August 4, 2015  
File: 191711607

**Reference: Additional Information and Review  
Newbury Street/Seaport Loft Development Project  
Newbury Street, Portland, Maine**

Attachment: email from Wayne Chadbourne of Haley & Aldrich, dated July 31, 2015  
Revised Table 1 prepared by Haley & Aldrich

Section A-A
1" = 10'

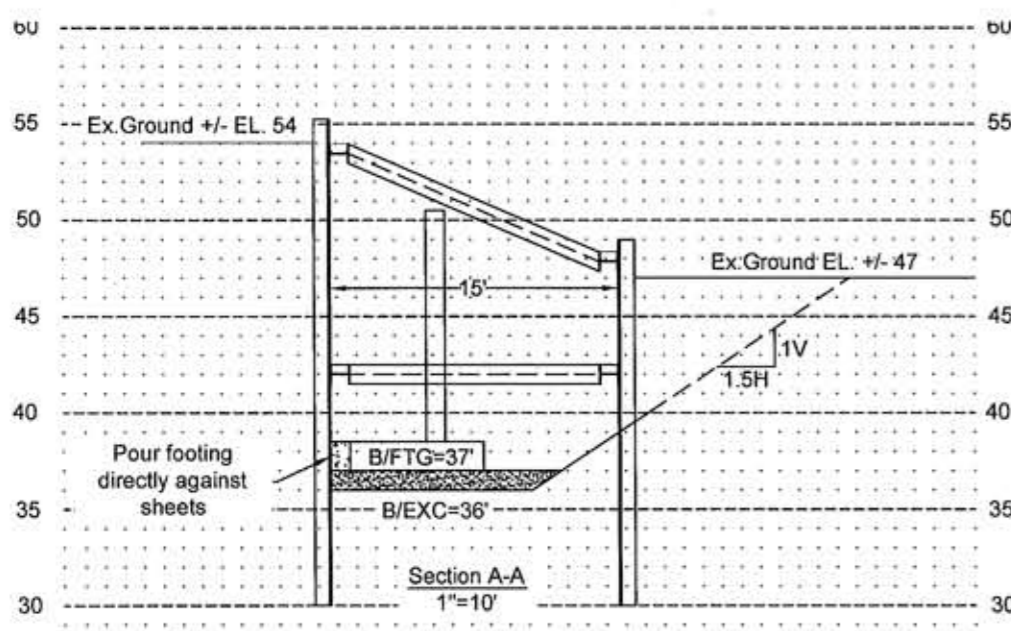
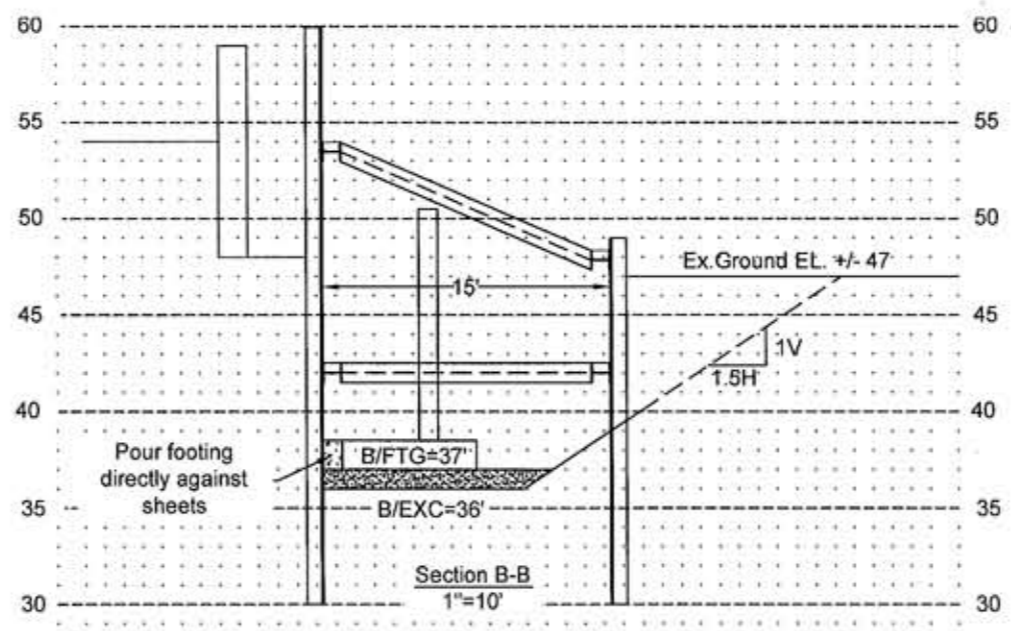
This letter provides a revision to our letter dated July 27, 2015 regarding the above referenced project. In the conclusion of the letter we indicated that the cause of that the ground surface movement behind the wall (tension cracks) and settlement that caused the distress to the adjacent properties is likely due to a combination of the wall settlement and vibration from the extraction of the sheet piles densifying the granular soils above the clay. We also indicated that global instability is not the likely cause of the ground movement and/or settlement at the Site. Our letter did recommend the drilling of two additional test borings to further refine the shear strength parameters for the clay in the ground improvement zone located beneath the retaining wall. Since our letter was issued, we participated in a conference call on July 28<sup>th</sup> with various parties involved with the project including personnel from the City of Portland, the developer (113 Newbury Street), Haley & Aldrich (H&A), and GEI Consultants. The main point of the conference call was to discuss the need for the drilling of the proposed additional test borings.

Based upon the discussions made during the conference call, H&A provided additional data to include the calculated global factors of safety varying strength parameters for the clay; the results of which are highlighted in the attached Table 1. Further explanation of the results is provided in the attached email prepared by H&A. In summary the table indicates a range of the factor of safety that varies from 1.2 to 1.9 for the soil Profile No. 1, depending on the strength of the soil in the ground improvement zone below the wall. It is our opinion that the friction angle (strength) of soil is in the 15 degree to 20 degree range which corresponds to a global factor of safety that varies between 1.5 and 1.6. As mentioned in our July 27<sup>th</sup> letter, a global factor of safety of 1.5 is considered to be appropriate for this Site. In consideration of this additional information and global stability analyses results provided by H&A, it is our opinion that the additional test borings are not needed.

- surcharge loading doesn't significantly impact FS
- the material in the ground improvement zone needs to have an aggregate strength of  $\phi=15$  degrees to achieve a FS of 1.5 (the in-situ material is likely a "c- $\phi$ " material; we are ignoring the cohesion)
- blow counts from borings that would be needed to confirm a  $\phi$  of 15 degrees would likely be less than 4 bpf (very loose classification)

Recall that we are not modeling the presence of the sheets and grouted columns which are both currently present along/beneath some portions of the wall. Also the shear strength profile in the clay is still in our opinion conservative, especially in the upper clay zone (450 psf in profile no. 1) as all of the data collected by the design team for the project had shear strengths in excess of 450 psf in this zone. Also shear strength profiles do not take into account the likely increase in strength adjacent to the improved zone due to dissipation of pore pressure caused by presence of the crushed stone in the improved area.
